Rosefield Solar Farm

Applicant's Outstanding Responses to Actions from ISH1 and ISH2

EN010158/APP/8.24
Revision 01
Deadline 4
June 2026
Rosefield Energyfarm Limited

SHEET 5 OF 8

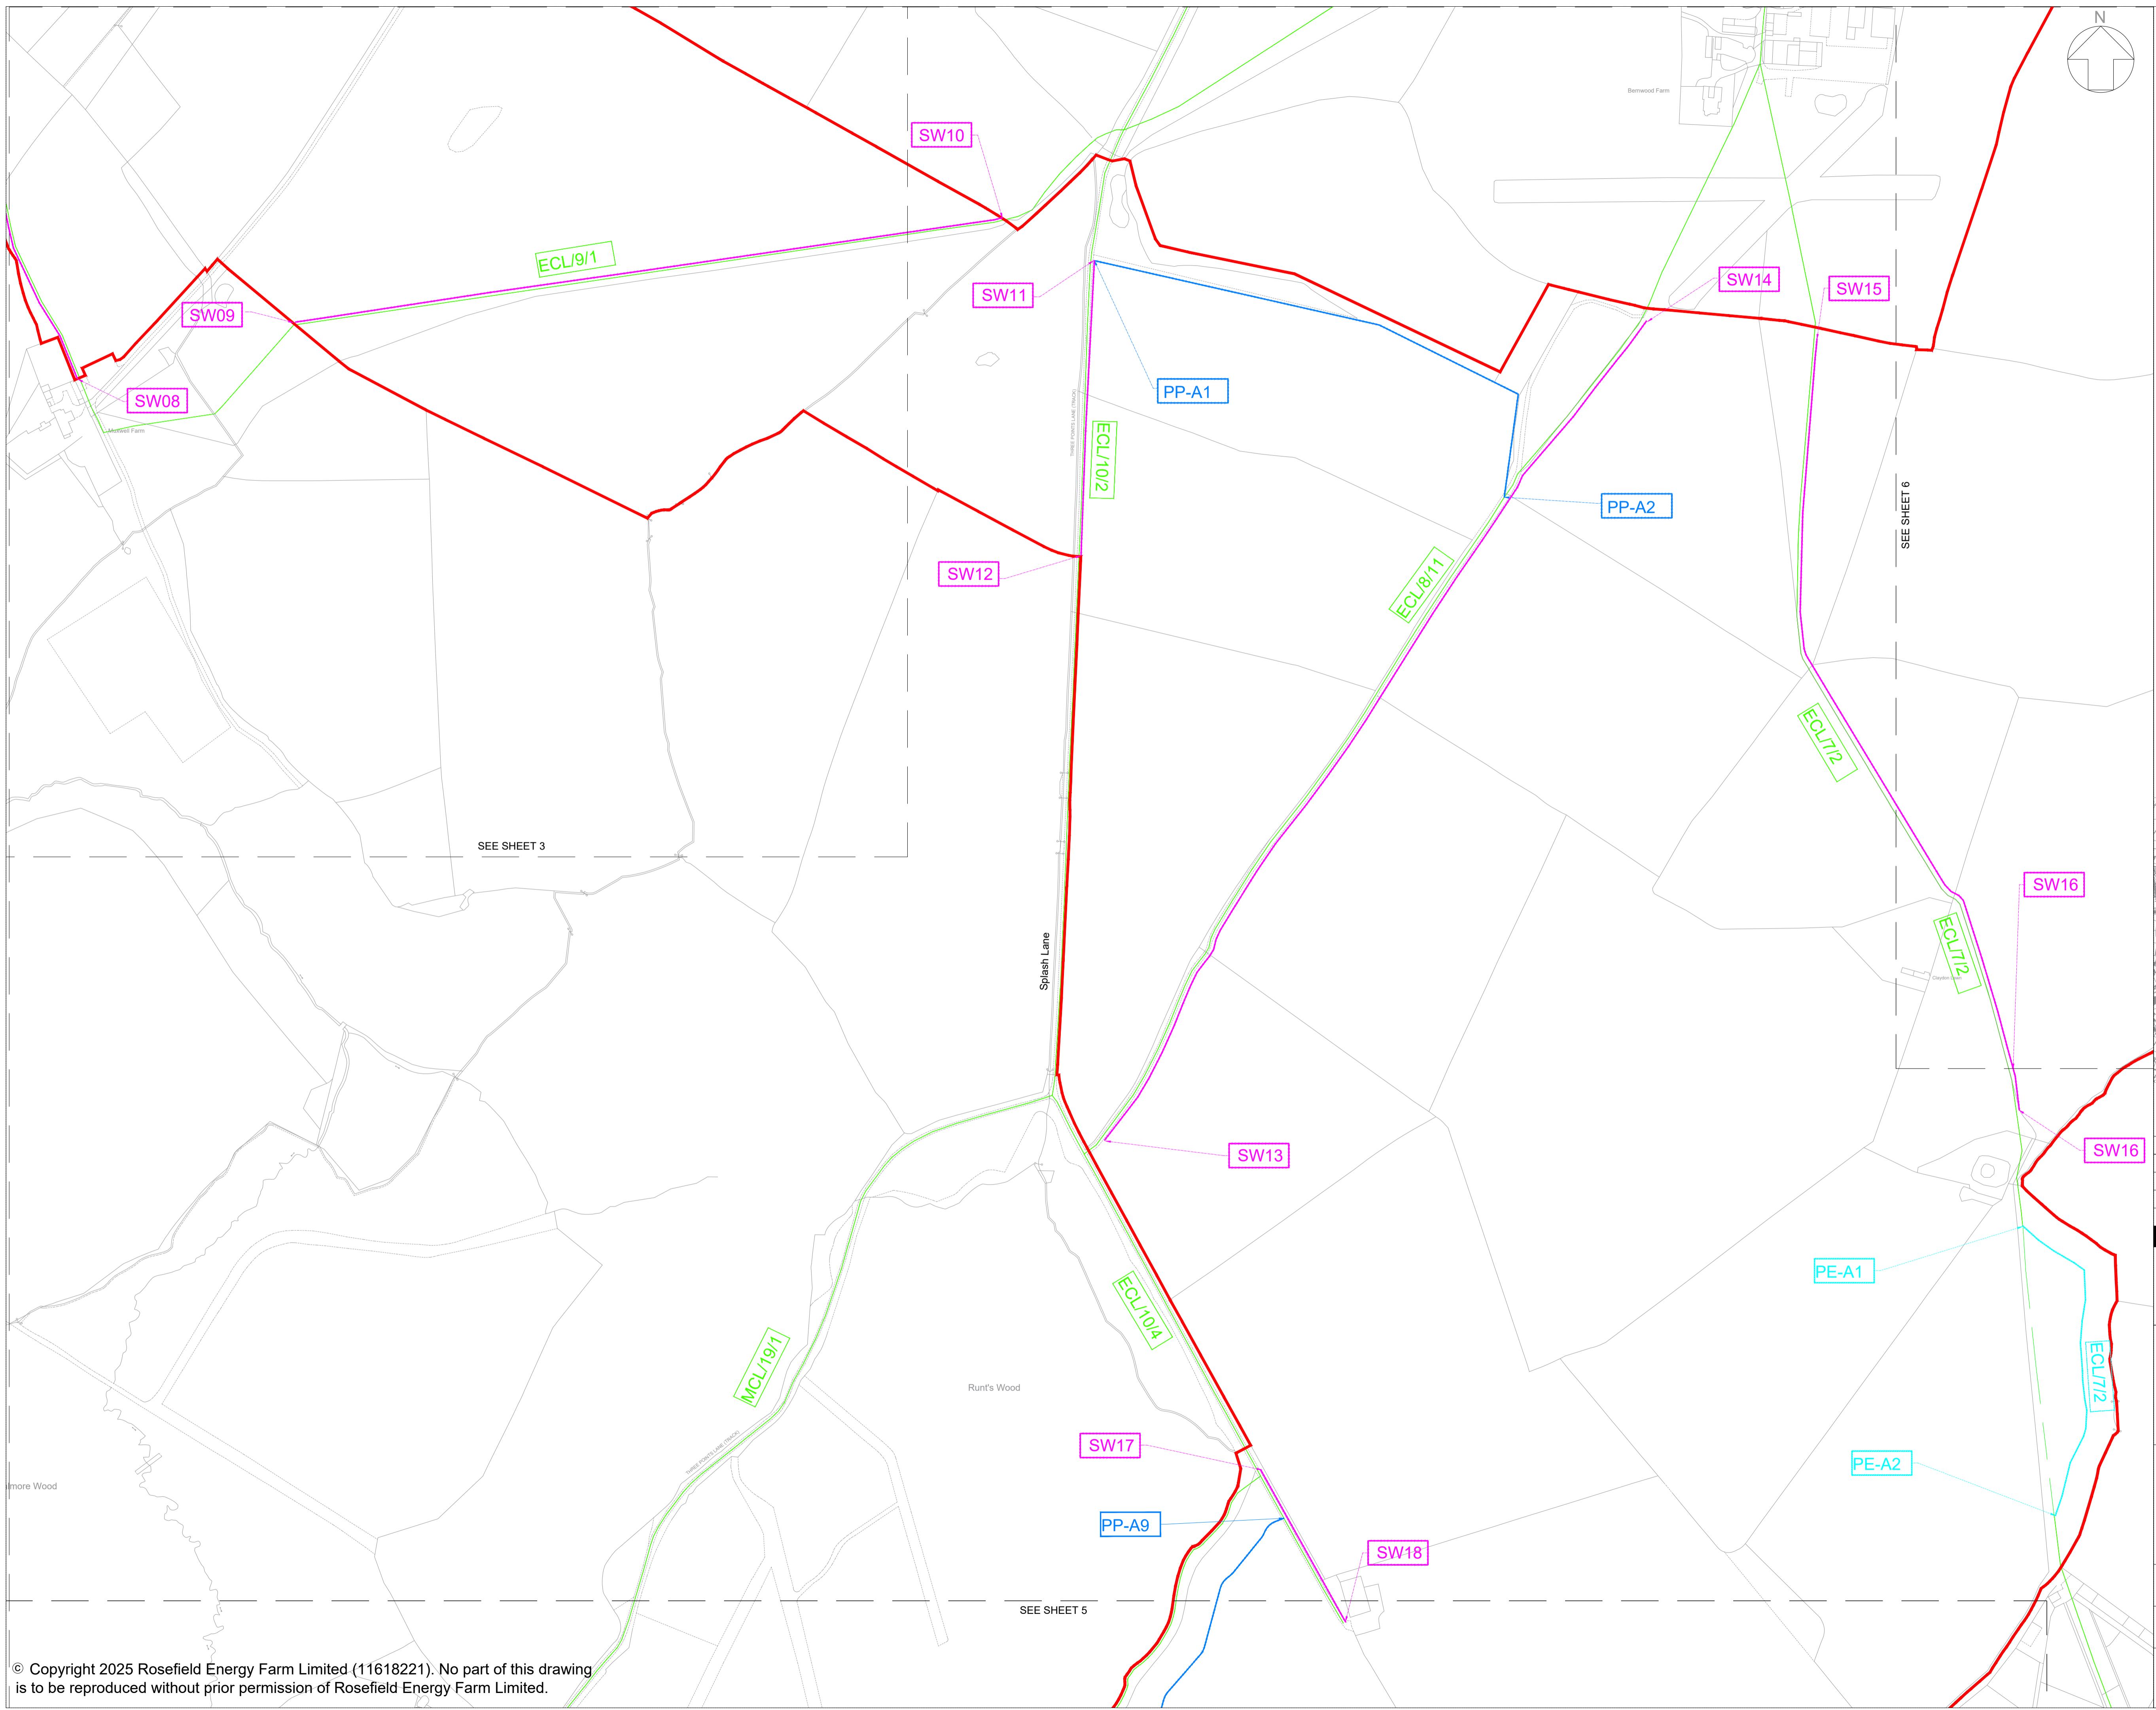
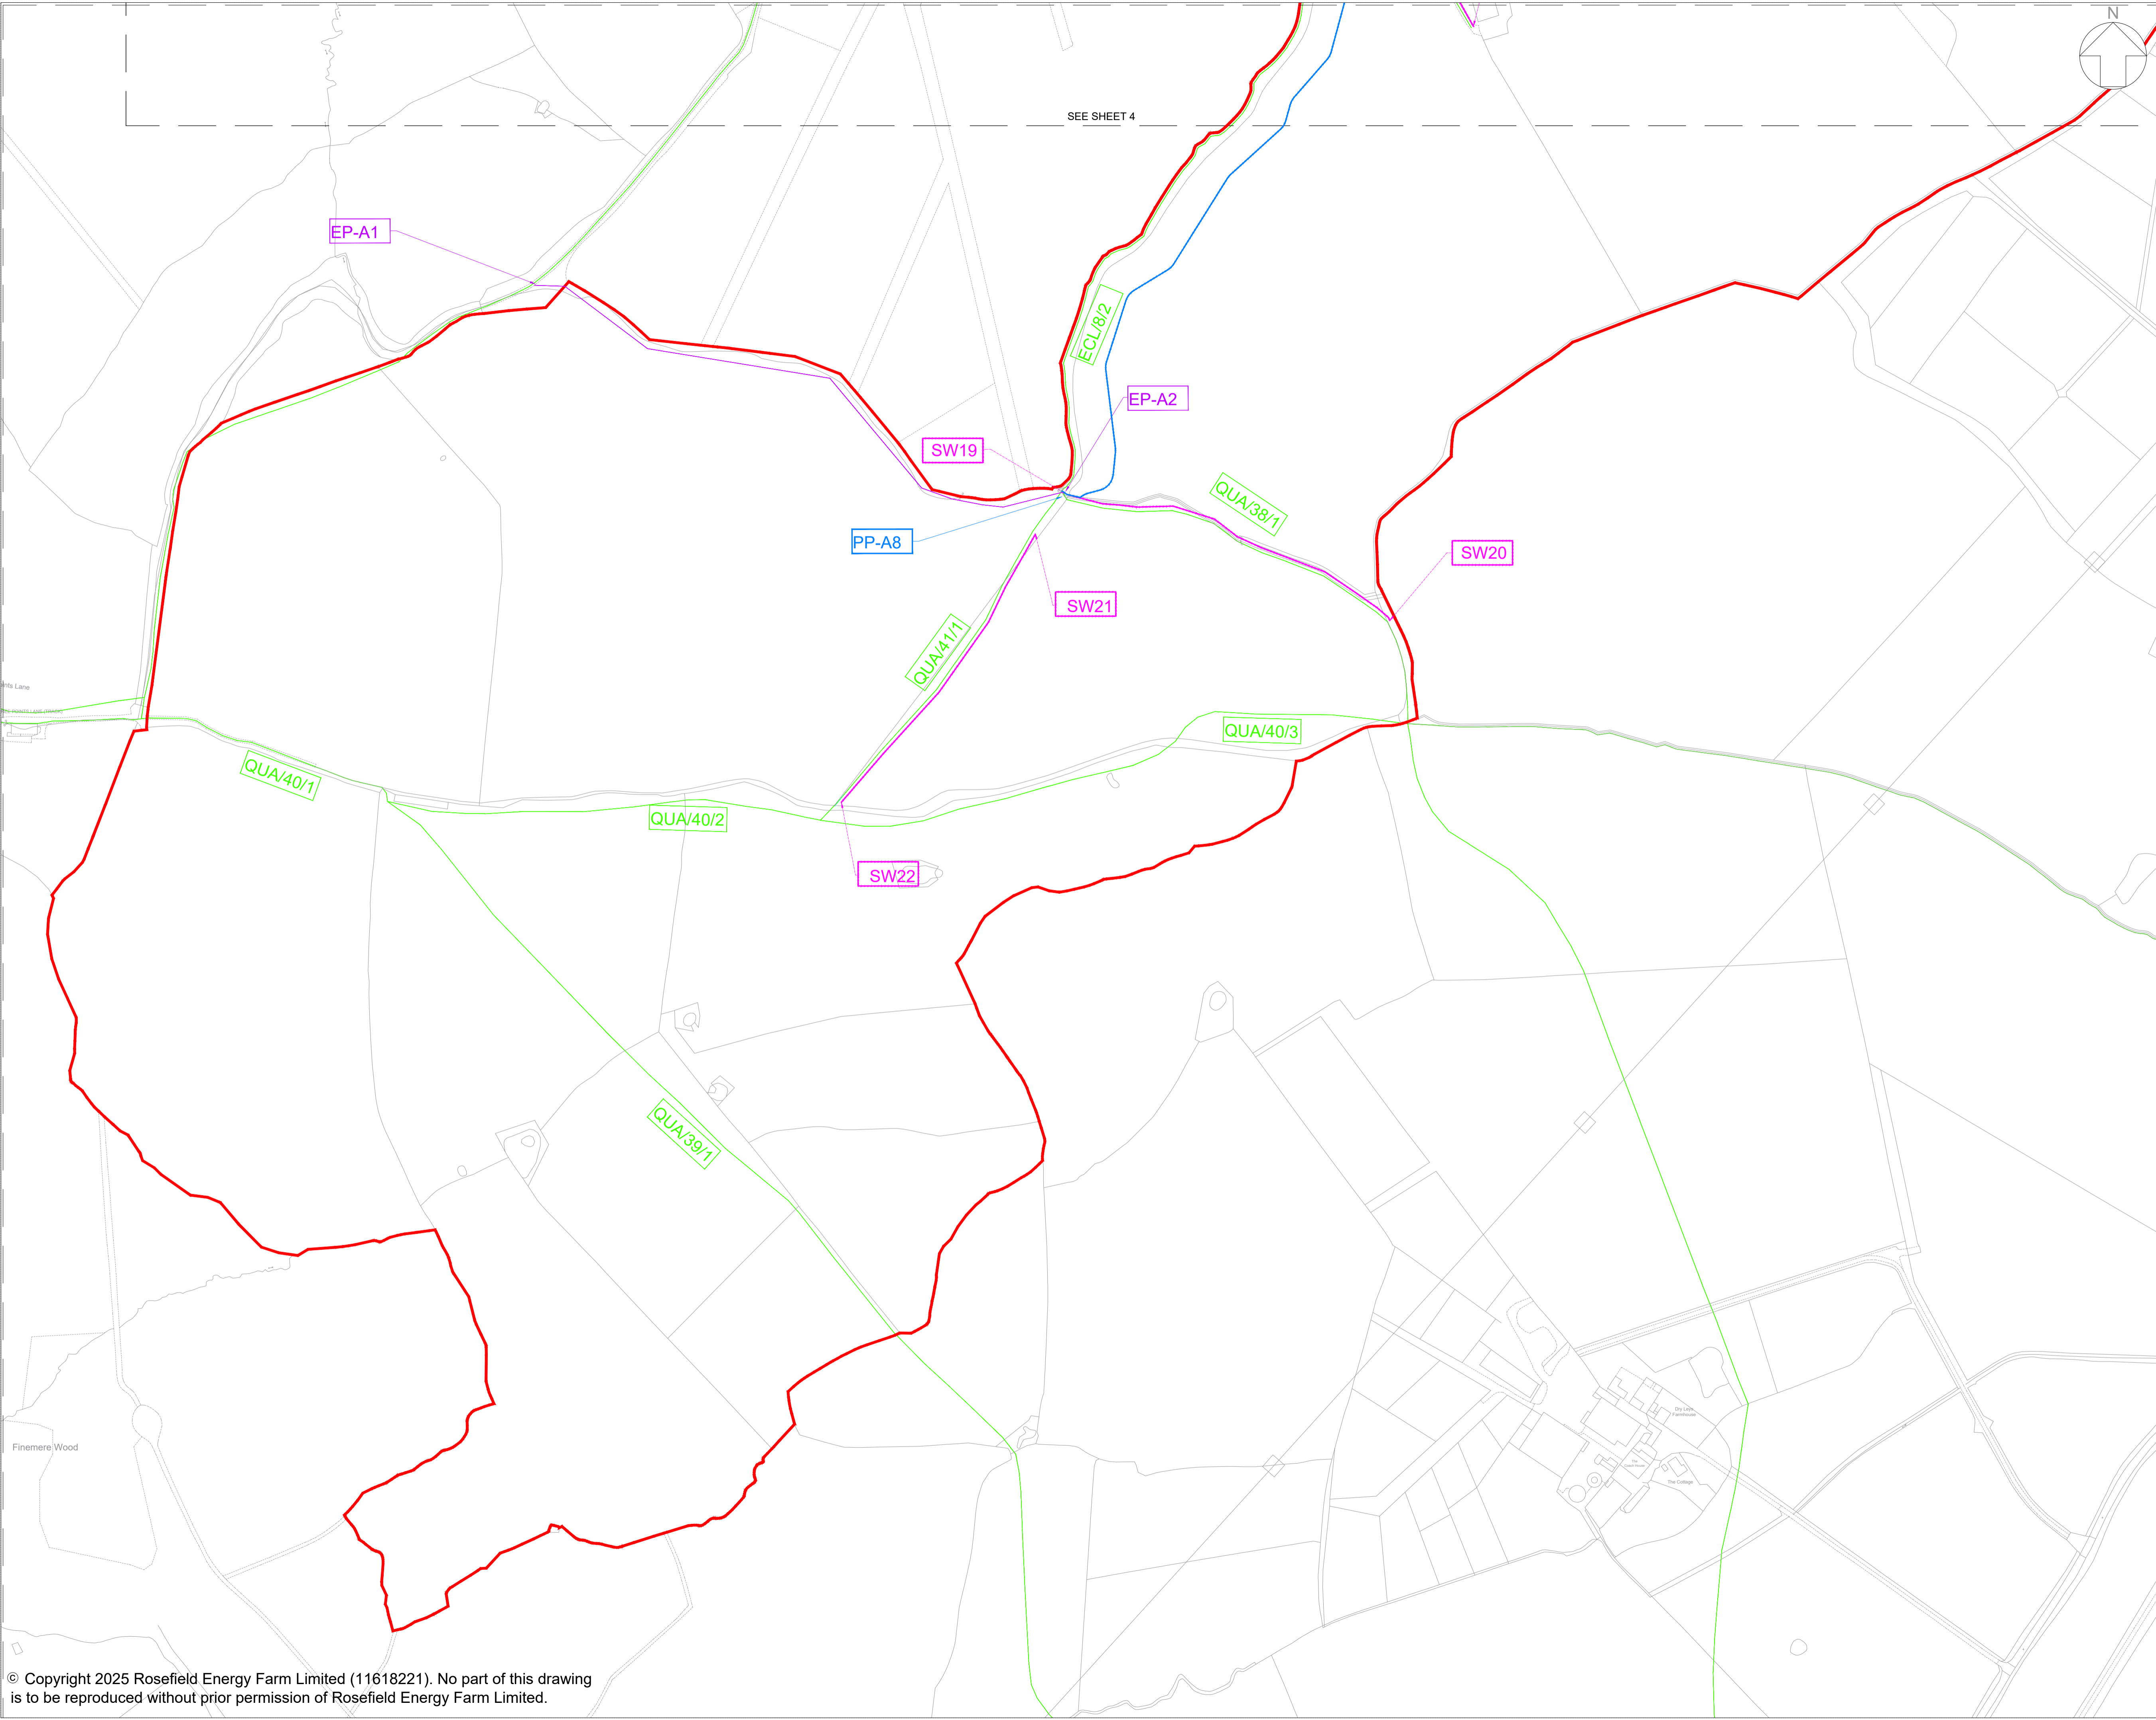
6	To update streets, access and rights of way plans to show existing private roads.	Applicant	4	The Streets Rights of Way and Access Plans [EN010158/APP/2.4.5] submitted at Deadline 4 have been updated to identify existing private roads which are marked with a yellow line on the plans.
7	To provide updated oCTMP regarding s278 and financial security.	Applicant	4	The Applicant has submitted an updated Outline CTMP [EN010158/APP/7.5.4] following agreement with Buckinghamshire Council.
8	To consider whether extension of compulsory acquisition powers in event of judicial review is required in light of recent DCO changes.	Applicant	4	<p>As explained by the Applicant during ISH2 (see Written Summary of Applicant's Oral Submissions at Issue Specific Hearing 2 (ISH2) [REP3-050]), article 23(3) extends the time limit for exercise of certain powers of compulsory acquisition (under article 31) in the event that the made Order is subject to a challenge under section 118 of the Planning Act 2008. This is considered warranted on the basis that the Proposed Development constitutes critical national priority infrastructure, the delivery of which should not be frustrated by unsuccessful legal challenges. This drafting also has precedent in the recently made Springwell Solar Farm Order 2026, so has been shown to be considered acceptable and appropriate by the Secretary of State.</p> <p>During ISH2, reference was made by Buckinghamshire Council to the reforms introduced under the Planning and Infrastructure Act 2025, with the suggestion that the effect of article 23(3) may now be achieved through that legislation. The Applicant understands this to have been a reference to section 56 of the PIA 2025, which amends sections 91 and 92 of the Town and Country Planning Act 1990 to provide for an extension to the implementation period of TCPA planning permissions subject to legal challenge in certain circumstances. Section 56 does not apply to NSIPs granted development consent under the Planning Act 2008.</p> <p>In light of the above the Applicant maintains its position that article 23(3) is appropriate and justified in the circumstances.</p>
